Application H02-0095-21
Location Land to the South of James Road North of A16 Crowland PE6 0AA
Proposal Proposed roadside services and recharge centre comprising eight pump petrol filling station and six HGV pumps with canopies, retail (Class E(a), sandwich servery (Class E(a), drive thru coffee shop (Class E (b), restaurant/cafe (Class E(b), toilets and shower facilities, two electric charging points, HGV parking area (61 spaces), new vehicular access/egress, security fencing, parking and landscaping.

Name Steve Branson
Address SHDC Priory Road

Date Submitted 13-08-21
For/Against Objections

**Figure 3 – Computer Noise Model**

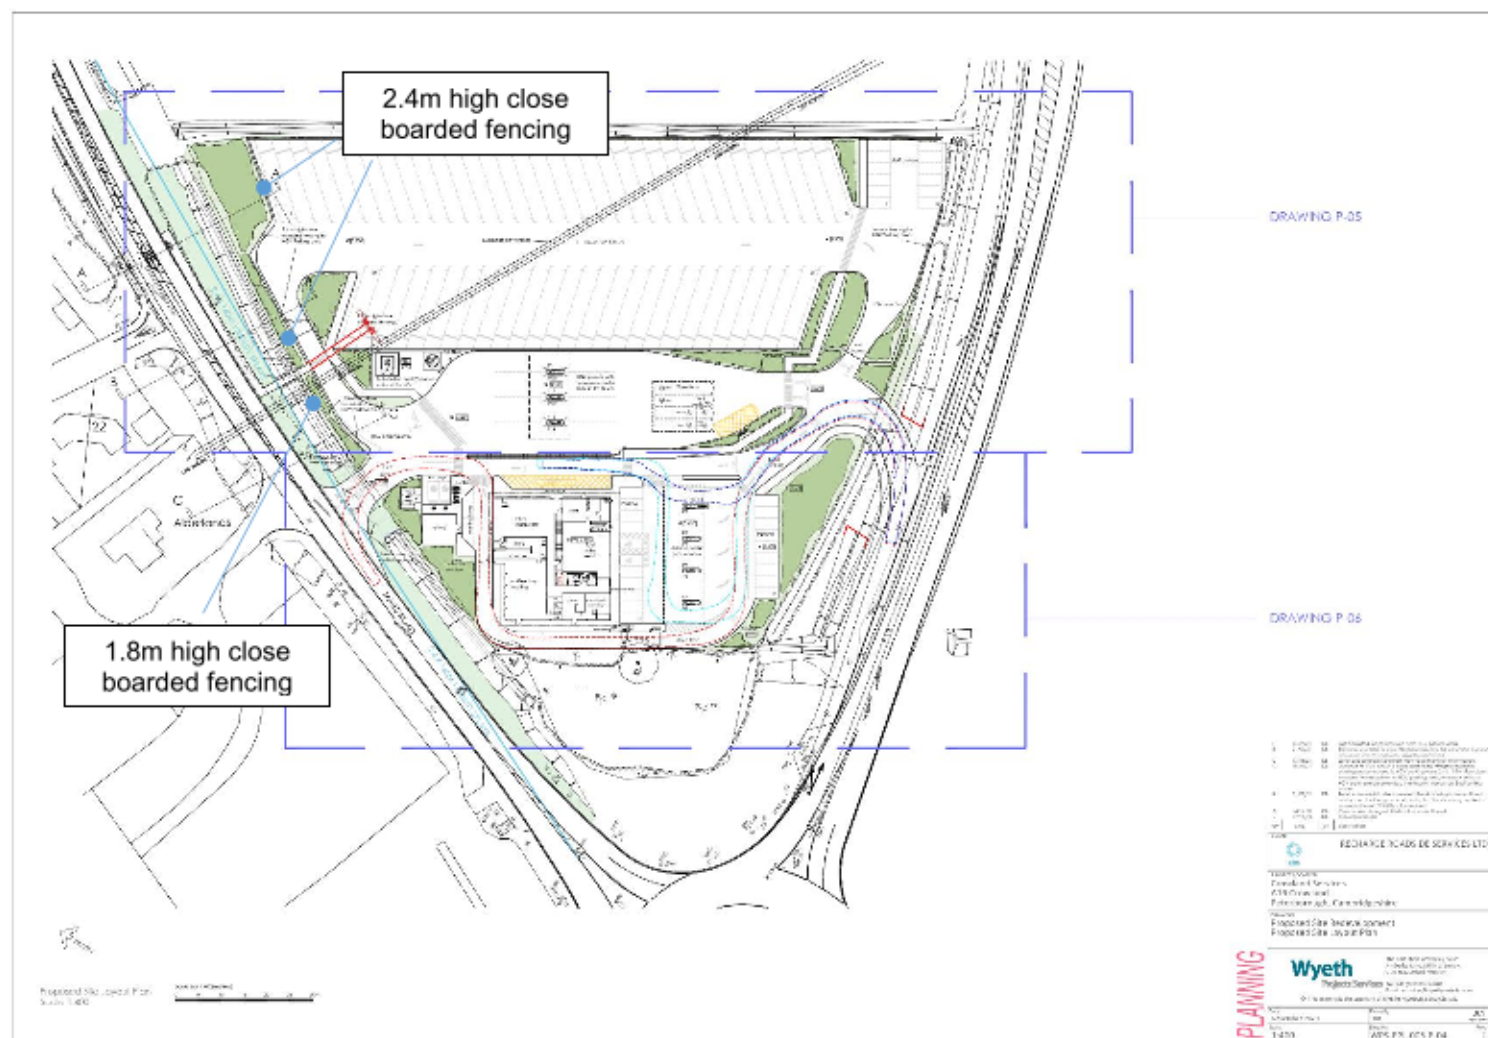
It is unclear whether noise from HGV's manoeuvring on site and the use of reversing beepers have been modelled as part of the assessment.
